3/17/26

I-5719B_U5800_Submittal S-008-4B Plans
MI-Engineering- Hydraulics Review

PROJECT REFERENCE NO. I-5719B / U-5800	SHEET NO. 05
ROADWAY DESIGN ENGINEER	HYDRAULICS ENGINEER
DOCUMENT NOT CONSIDERED FINAL UNLESS ALL SIGNATURES COMPLETED

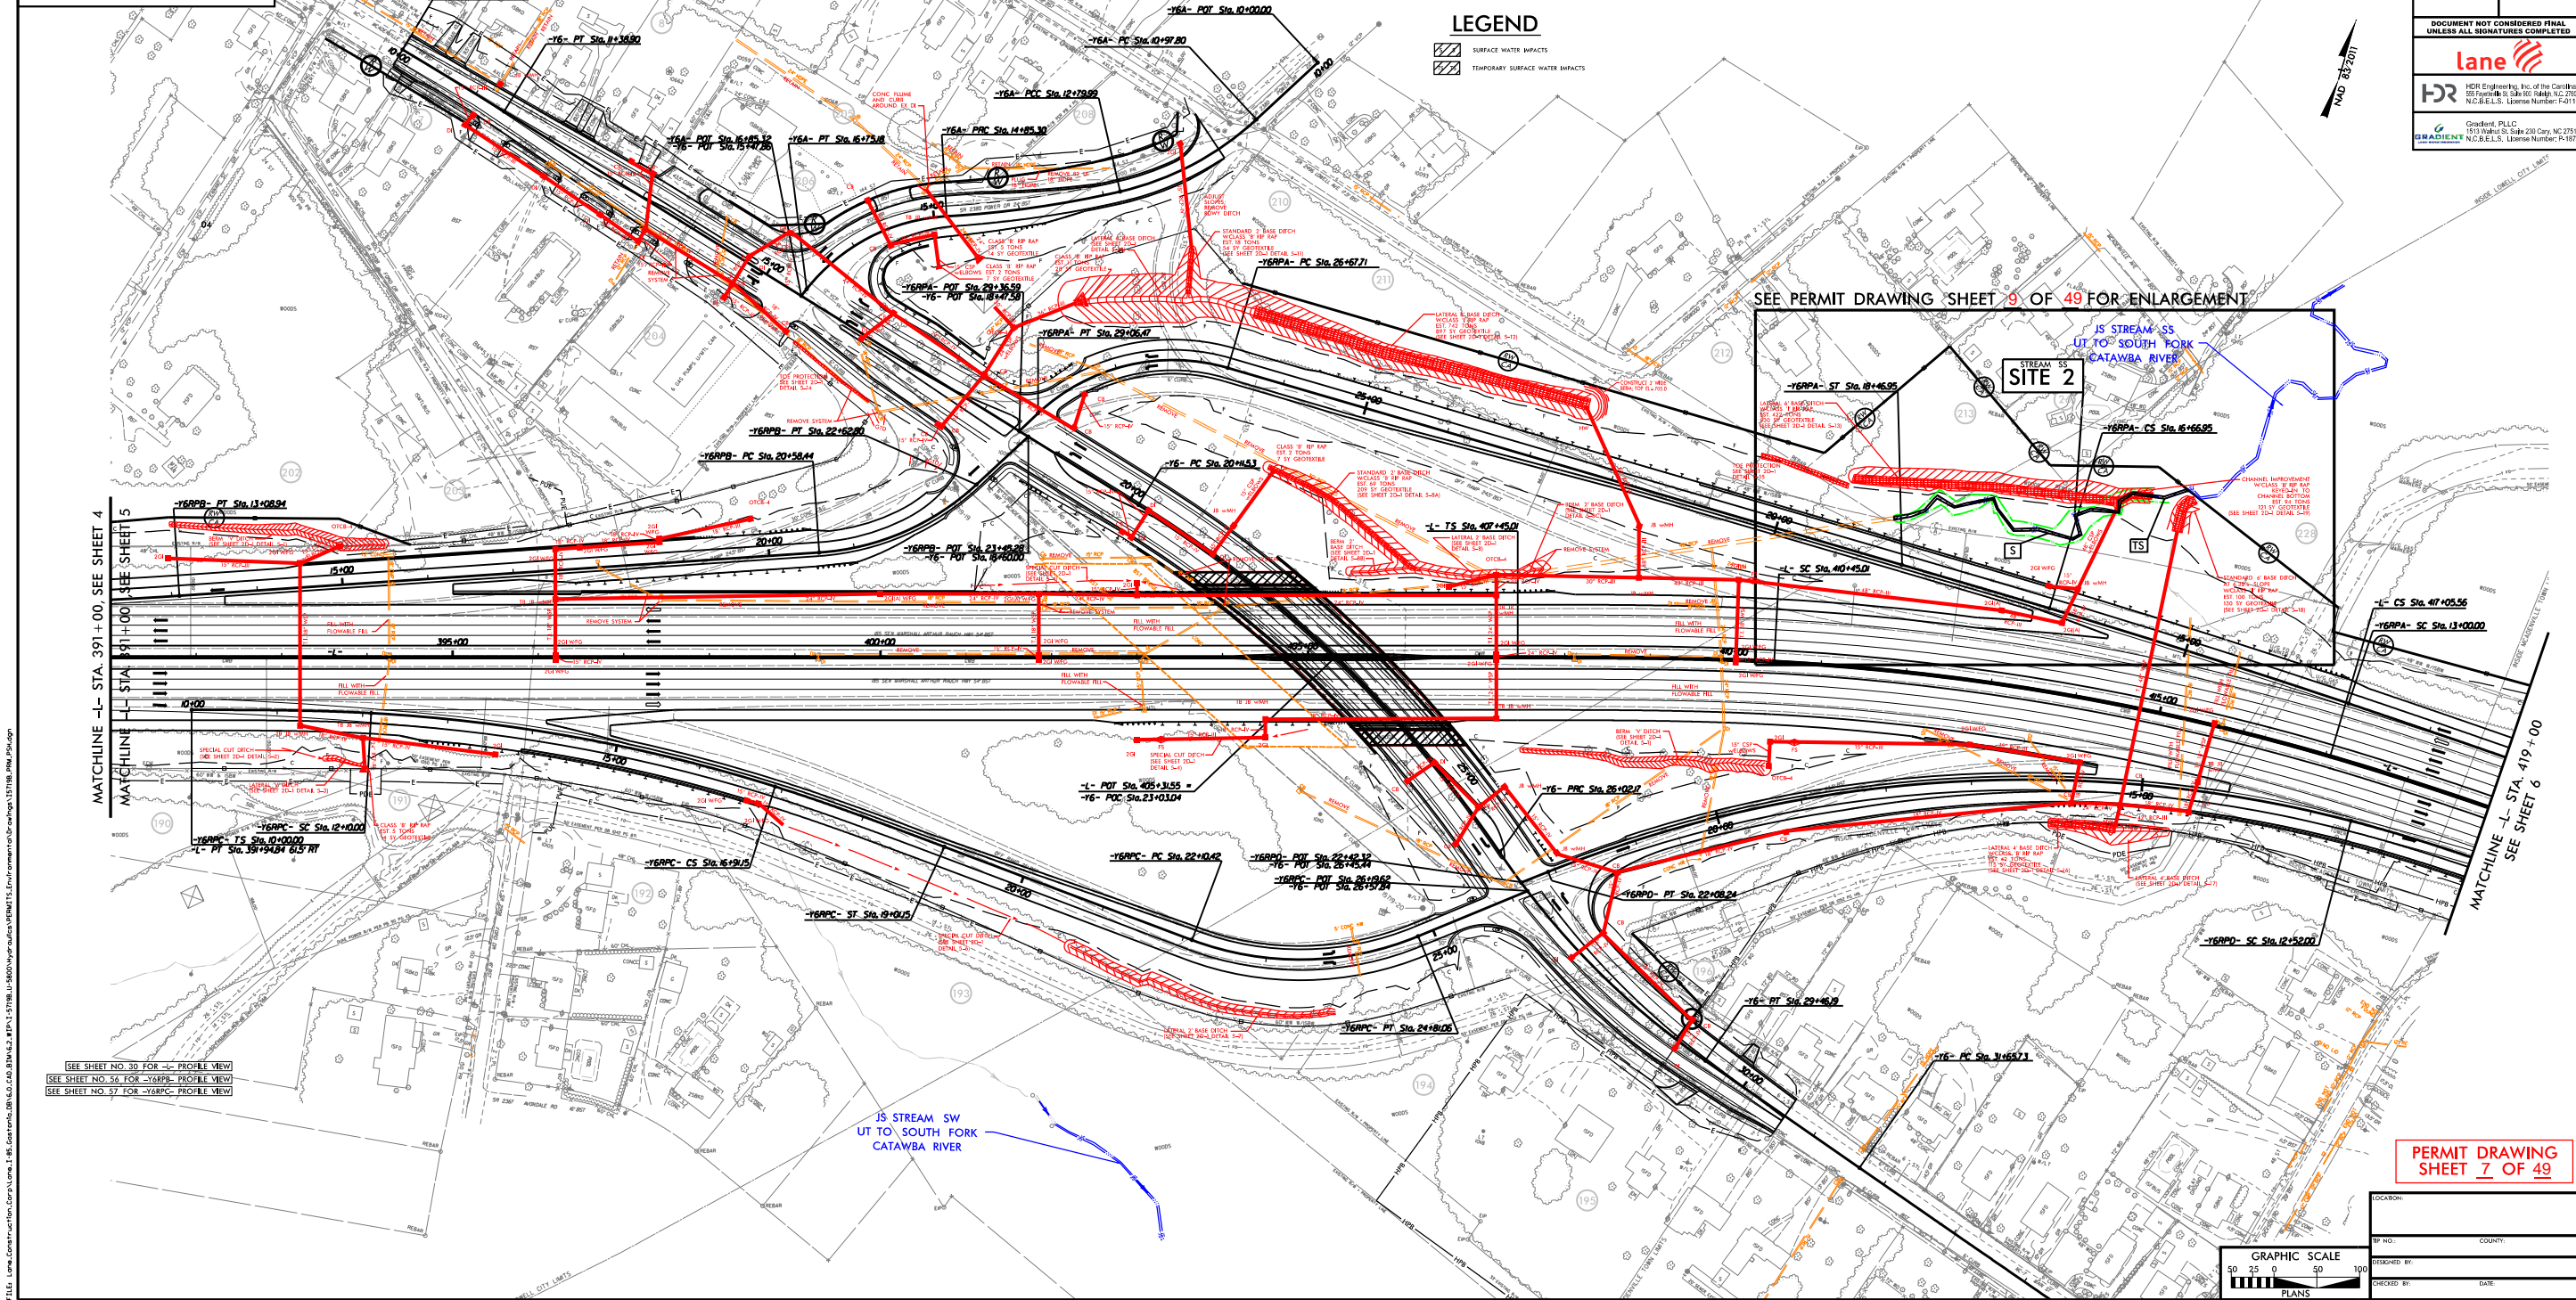
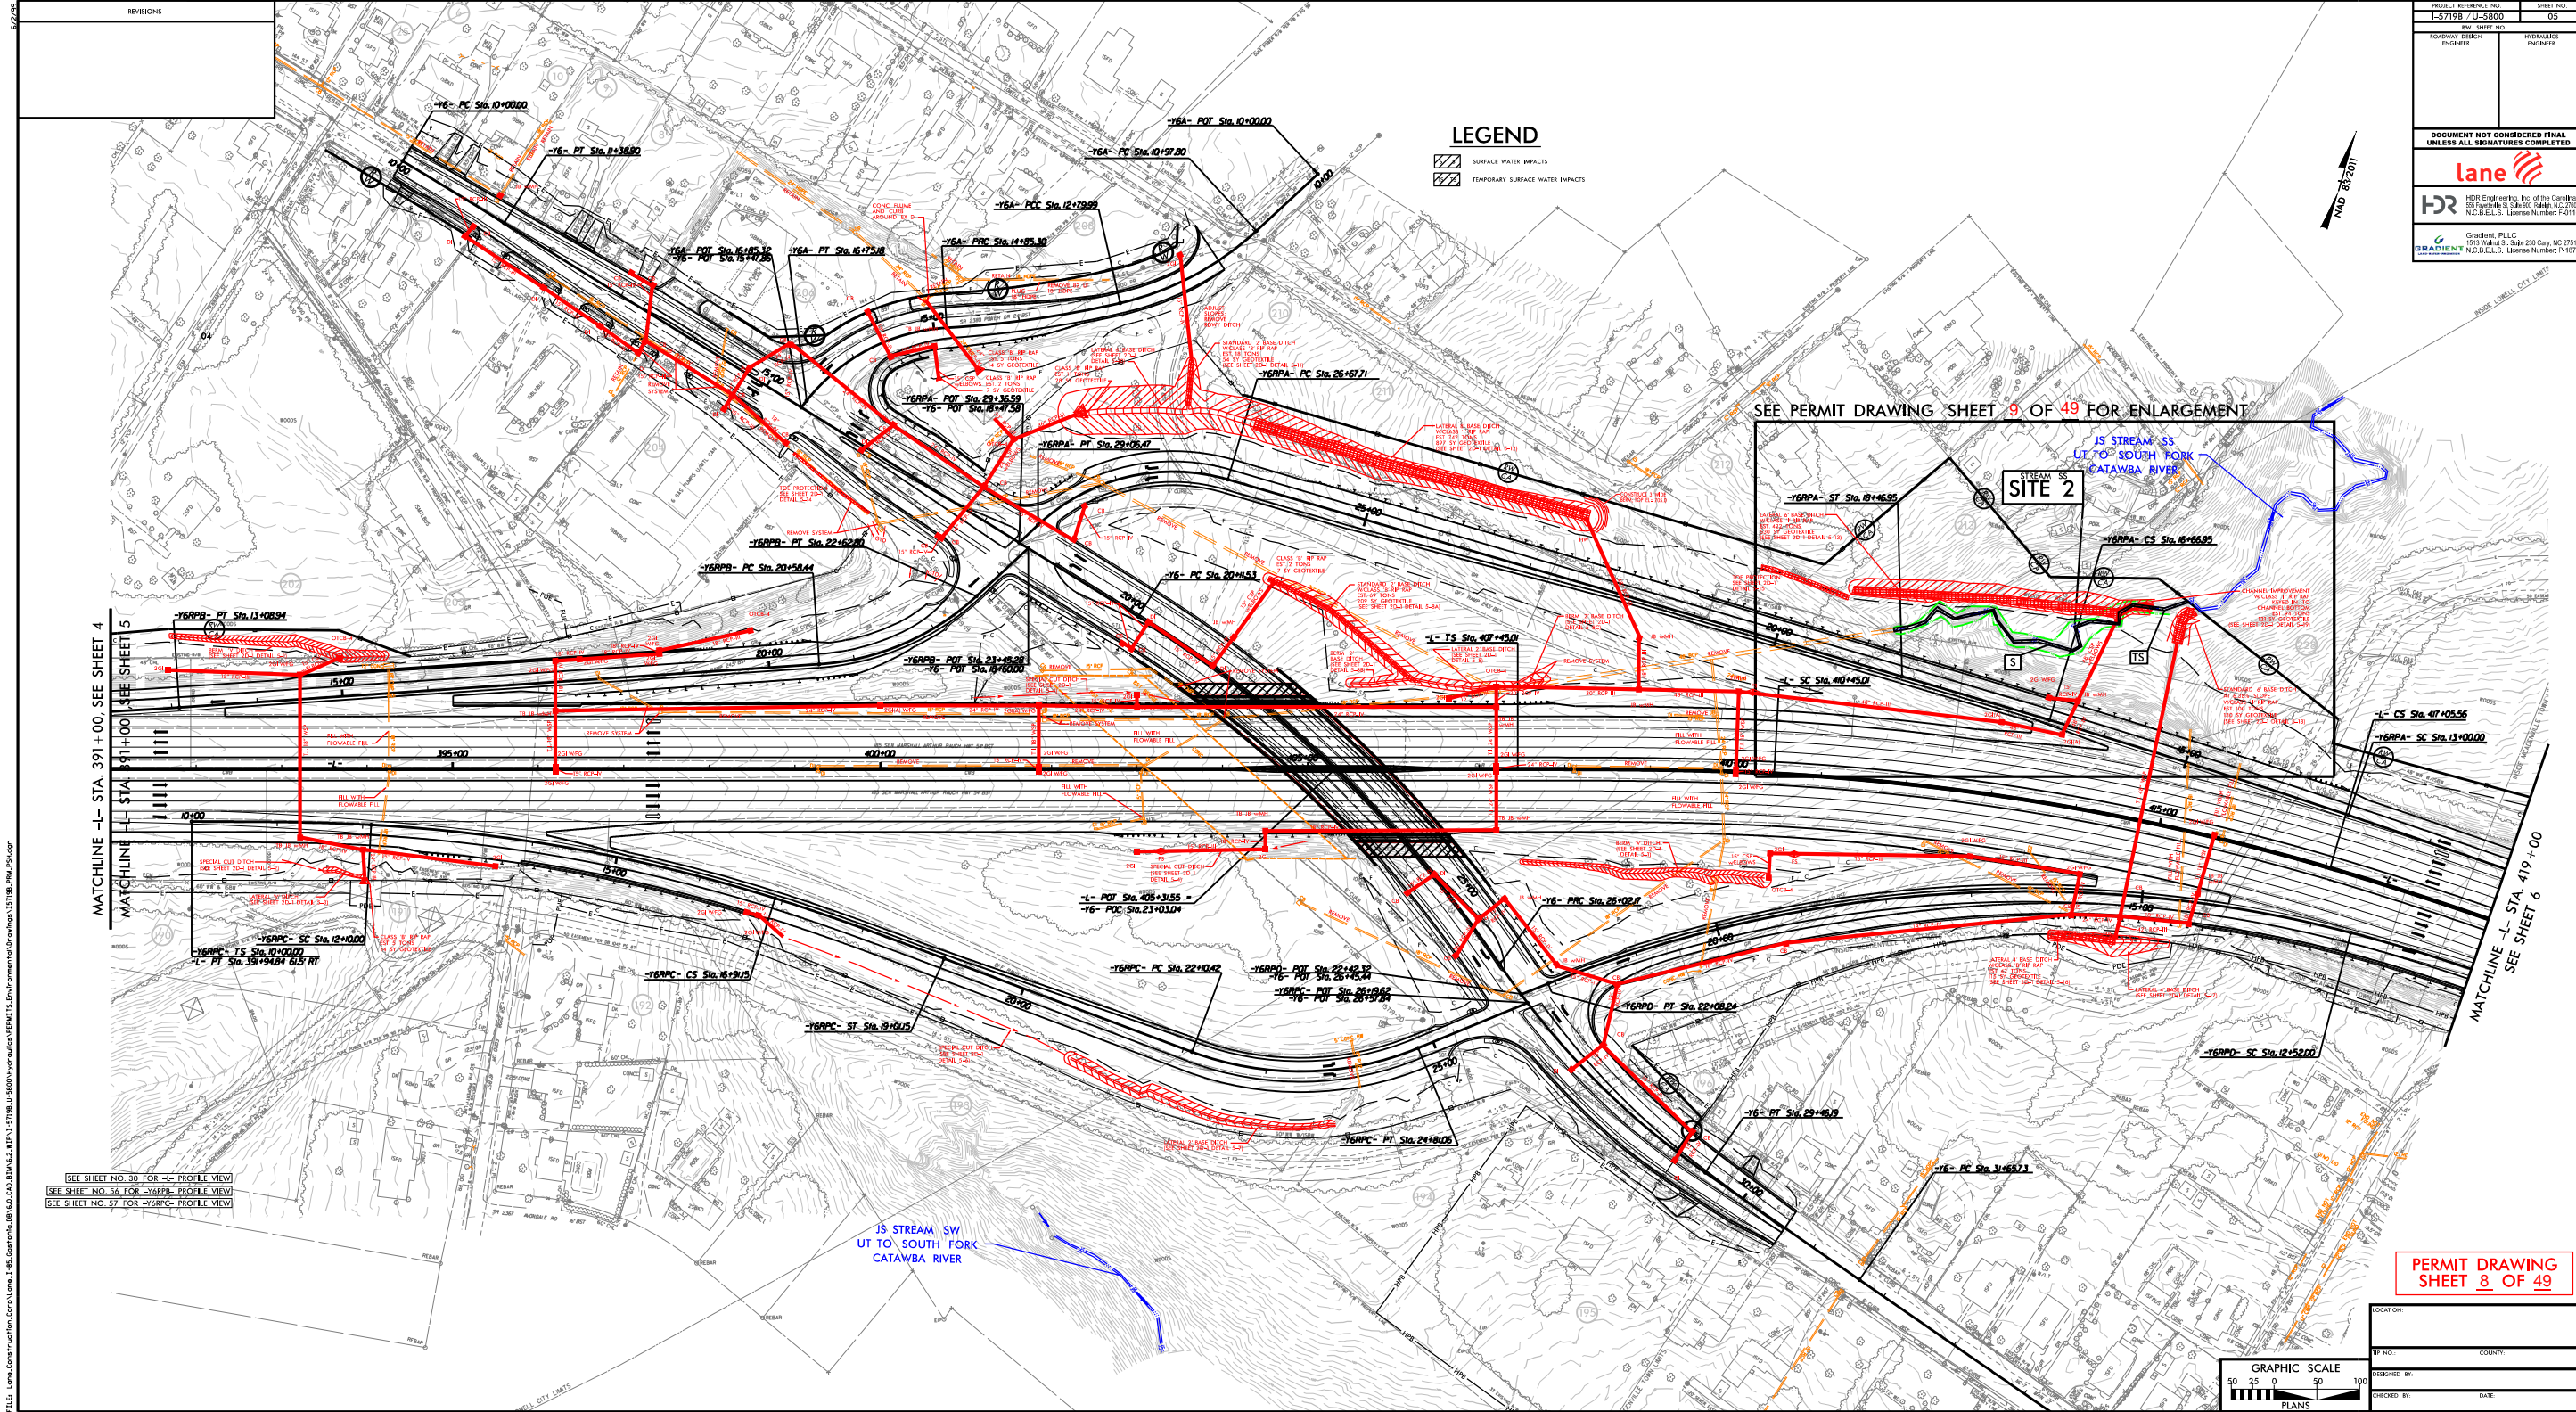
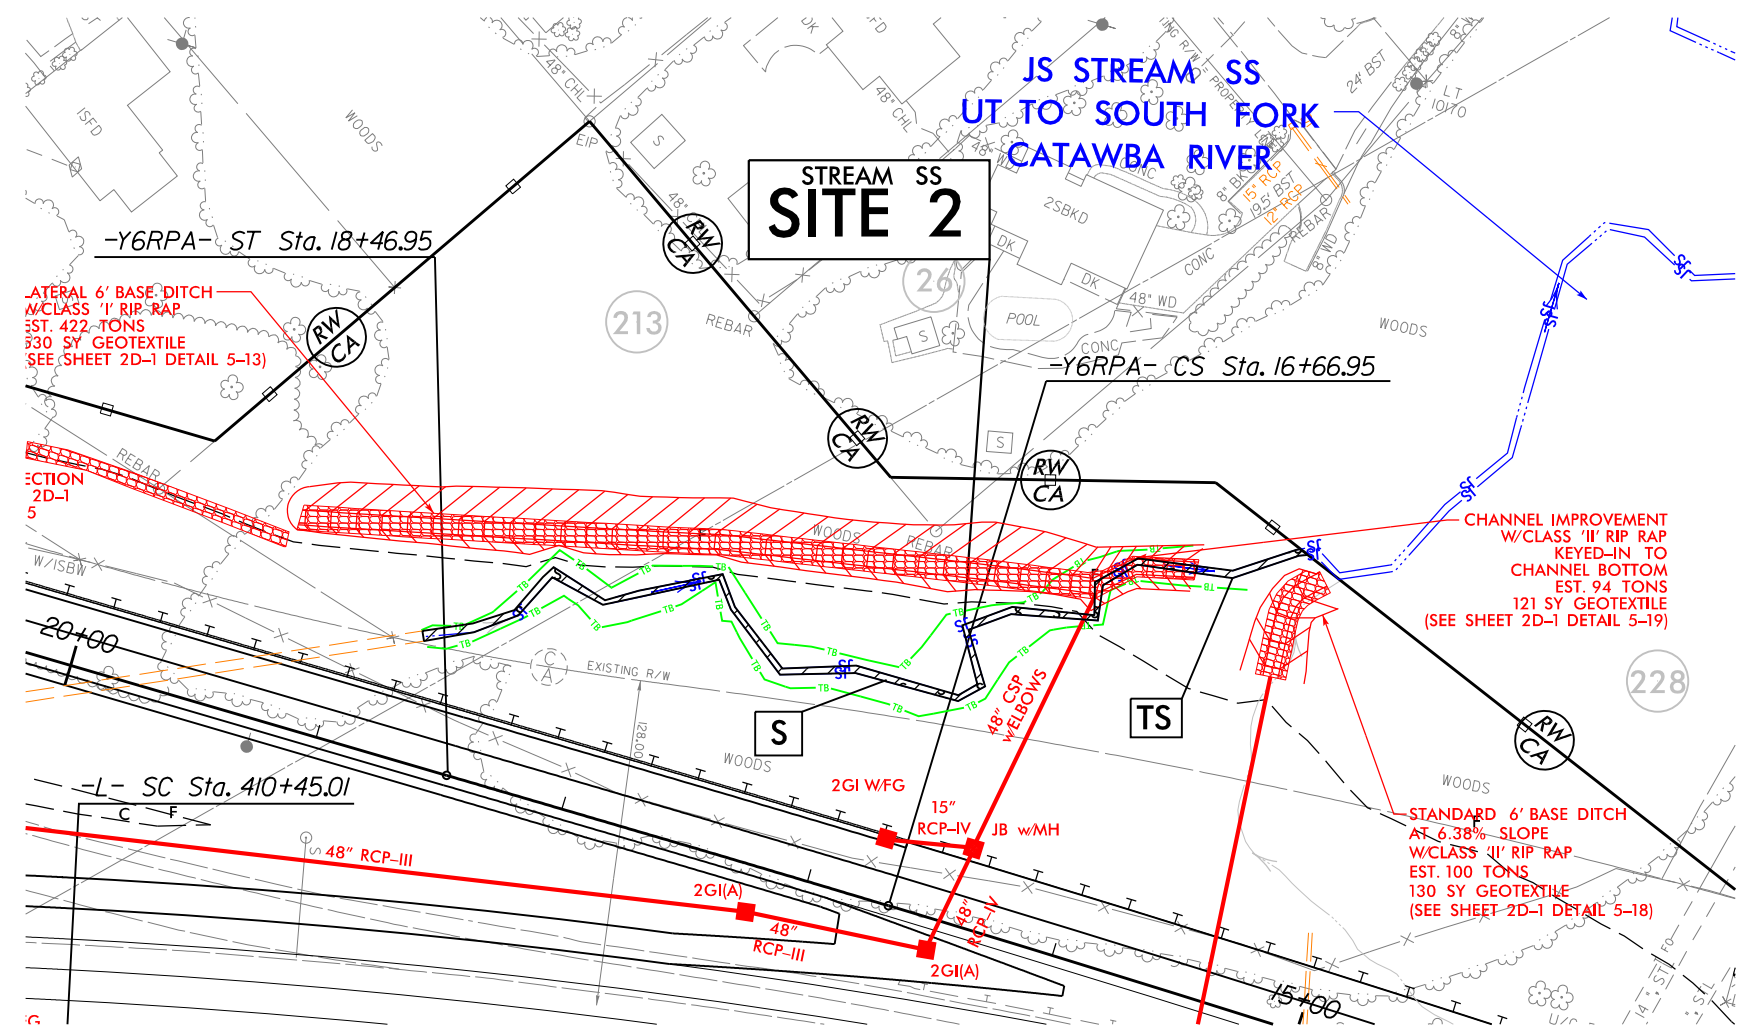
- Use pipe outlet channel improvement with rip rap embedded into stream bed instead of standard rip rap protection at outlet 48" csp right of station 16+25 -Y6RPA-. Carry the rip rap protection beyond bend in stream so stream is protected around bend and flow is directed into natural stream alignment.
 - Riprap revised to show in stream bed and past bend.
- Update highlighted drainage shown on markup.
 - Drainage was updated to reflect the updated roadway.
